SUBMISSION RE SSD-8996

AMENDED STATE SIGNIFICANT DEVELOPMENT APPLICATION – LORETO NORMANHURST SCHOOL REDEVELOPMENT (CONCEPT PROPOSAL AND STAGE 1)

OBJECTION TO PROPOSAL

Drawing Title
ELEVATIONS SHEET 2
Sheet Status
NOT FOR CONSTRUCTION

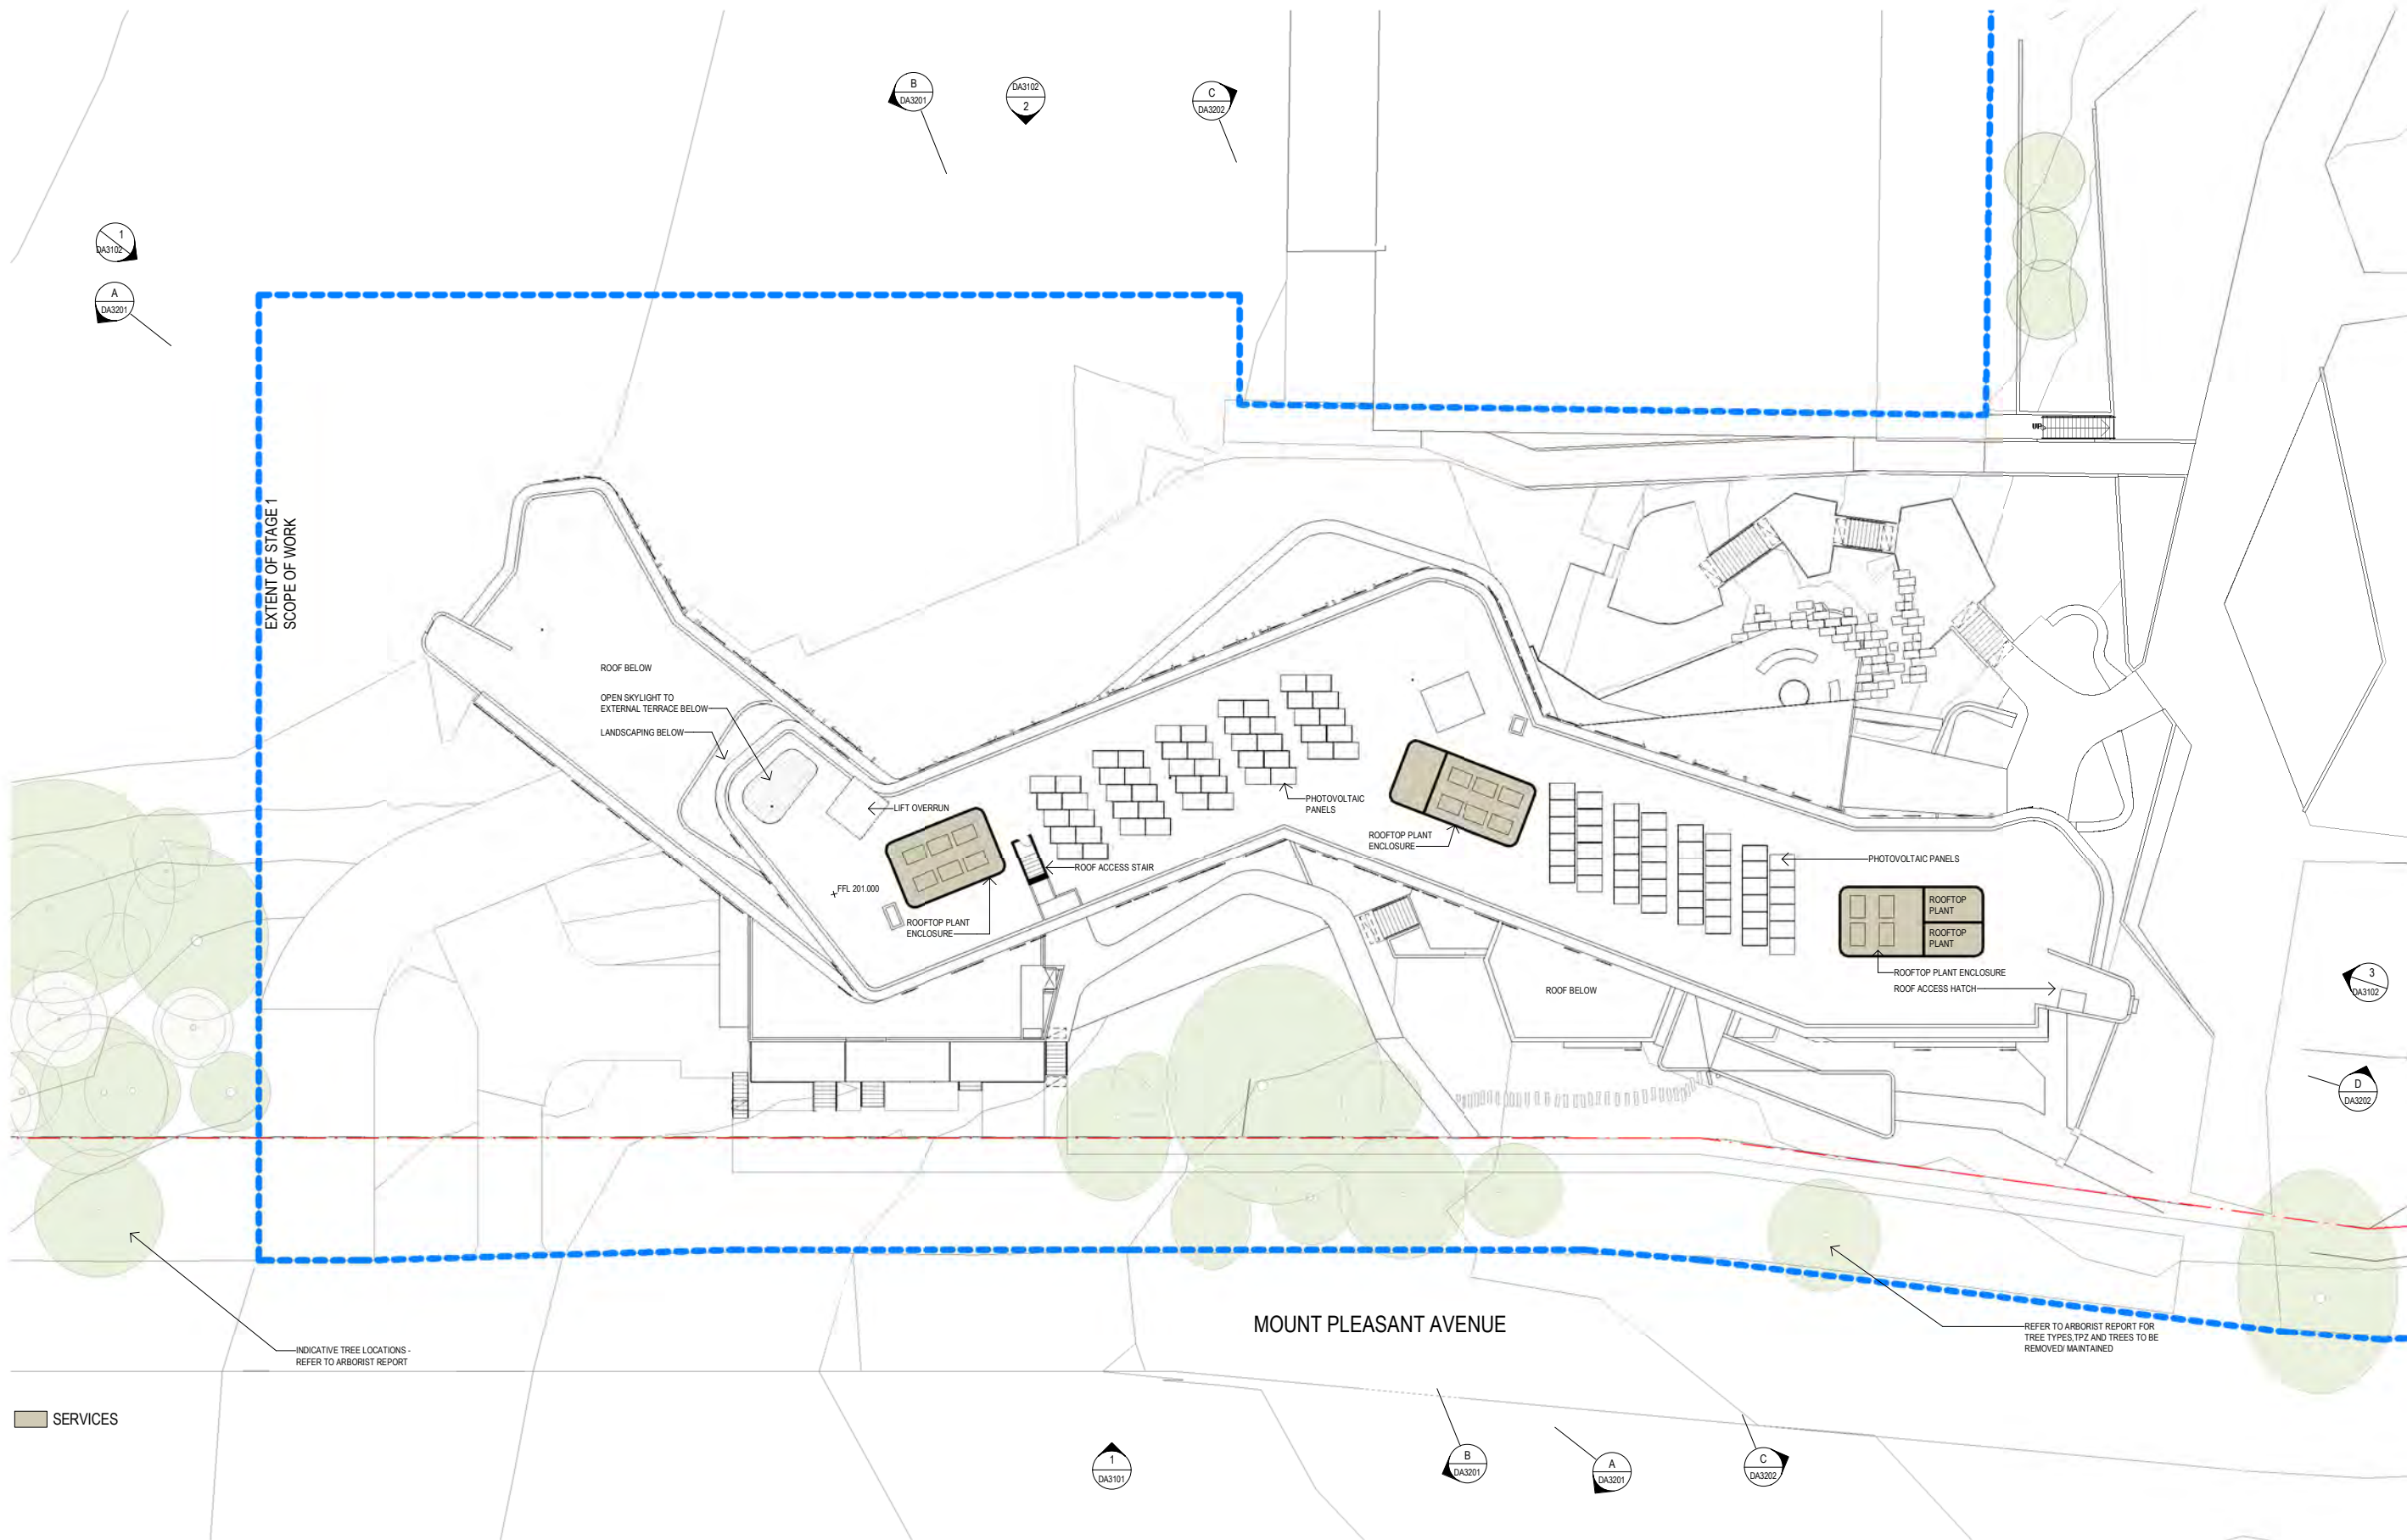
I understand the need for a modernised boarding school. However, even though one floor has been deleted from the original plan of the Boarding House, this building remains far too overpowering for the surrounding houses in the street. The height is too great and the length and design completely out of character with the residences in the street and the older buildings in the school.
